The Planning Inspectorate
[Via Planning Inspectorate website]

Our ref: XA/2024/100131
Your ref: EN010140

Date: 11 December 2024

We have reviewed the draft DCO, Environmental Statement (ES) and supporting documents submitted to the Planning Inspectorate as part of the above-mentioned application.

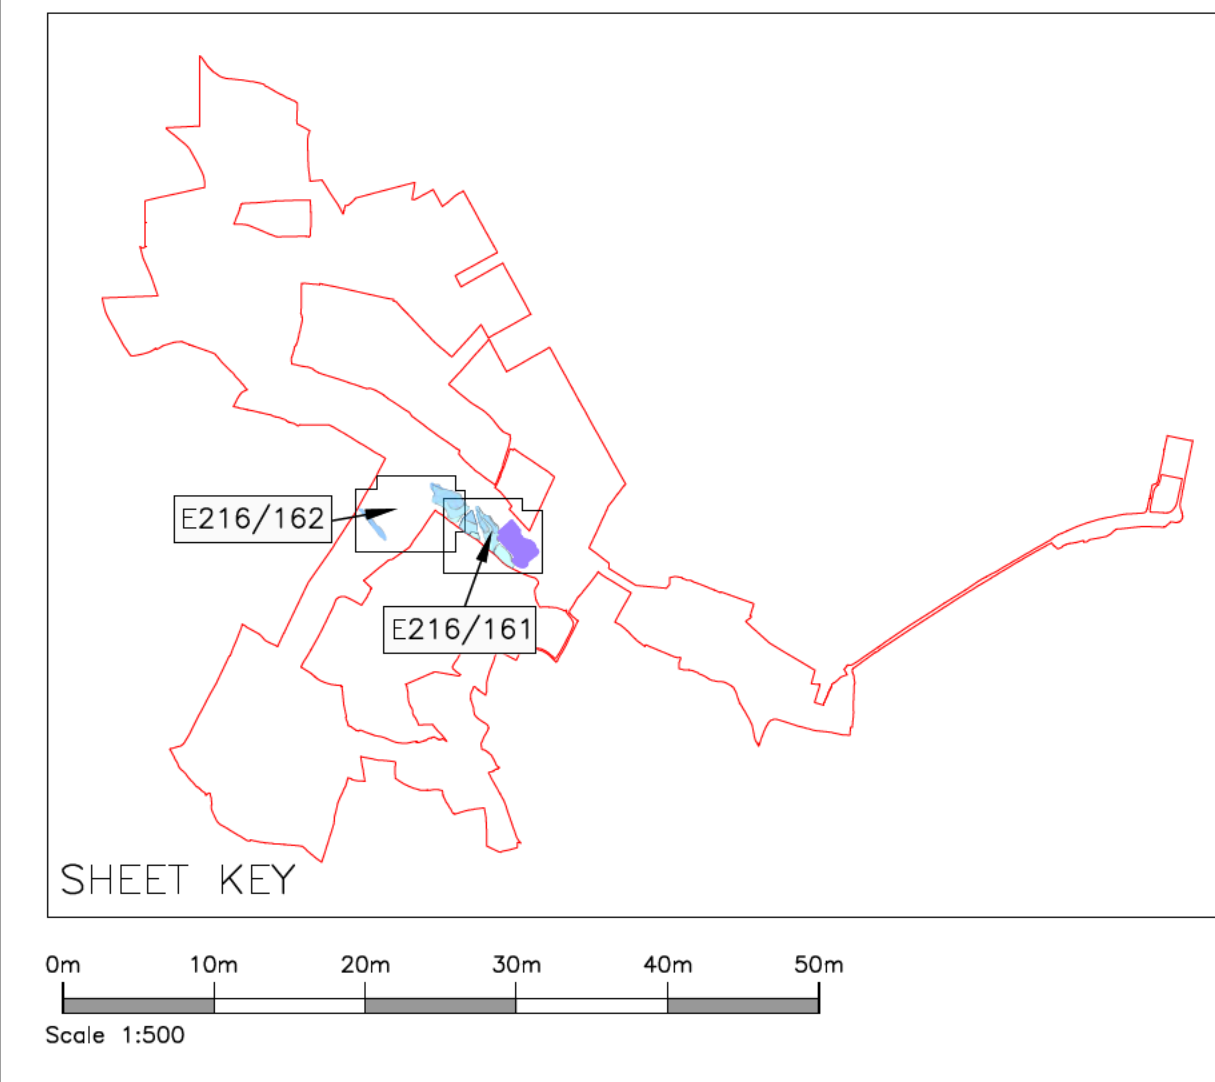
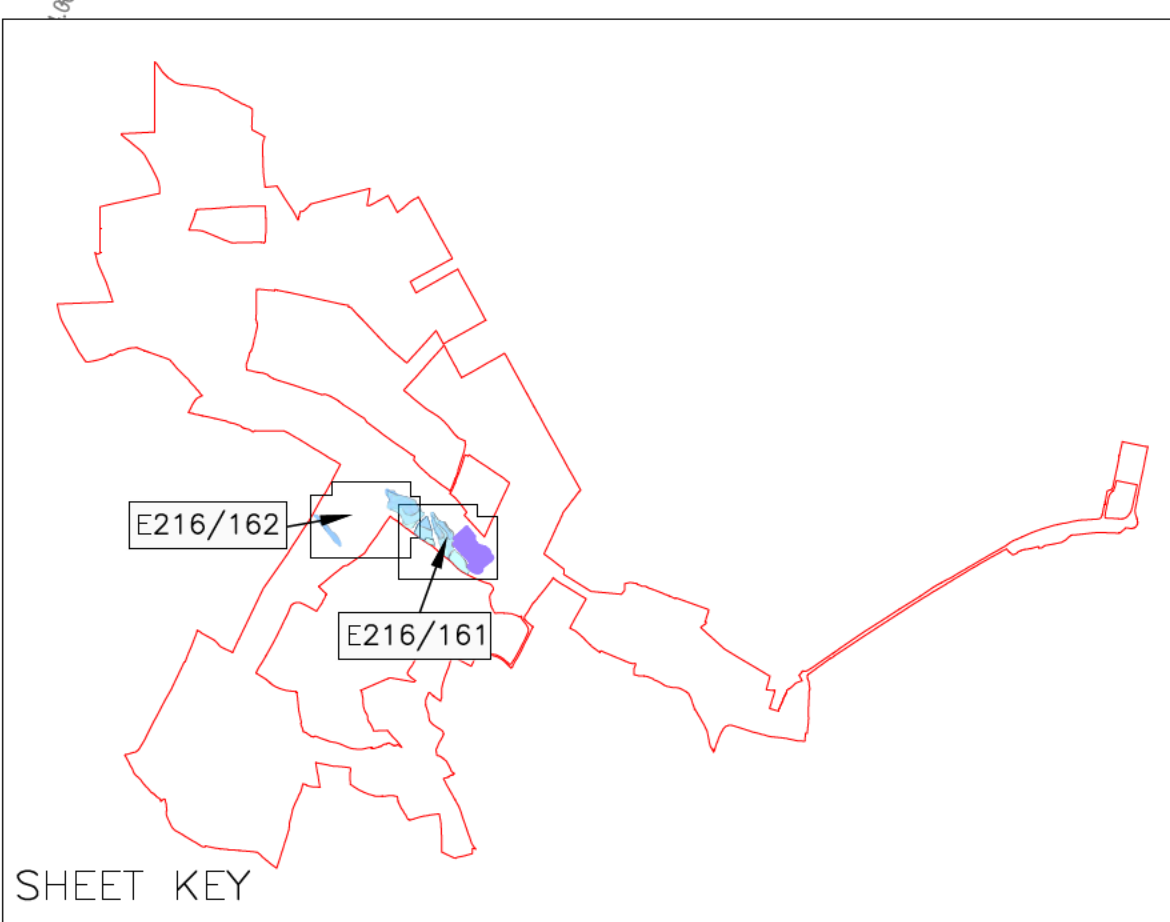
- We require further detail as to how the flood risk compensation scheme as proposed in the Flood Risk Assessment will be secured to ensure this development does not cause flood risk elsewhere. This detail should include phasing of works to ensure that there will be no net loss of floodplain during construction.
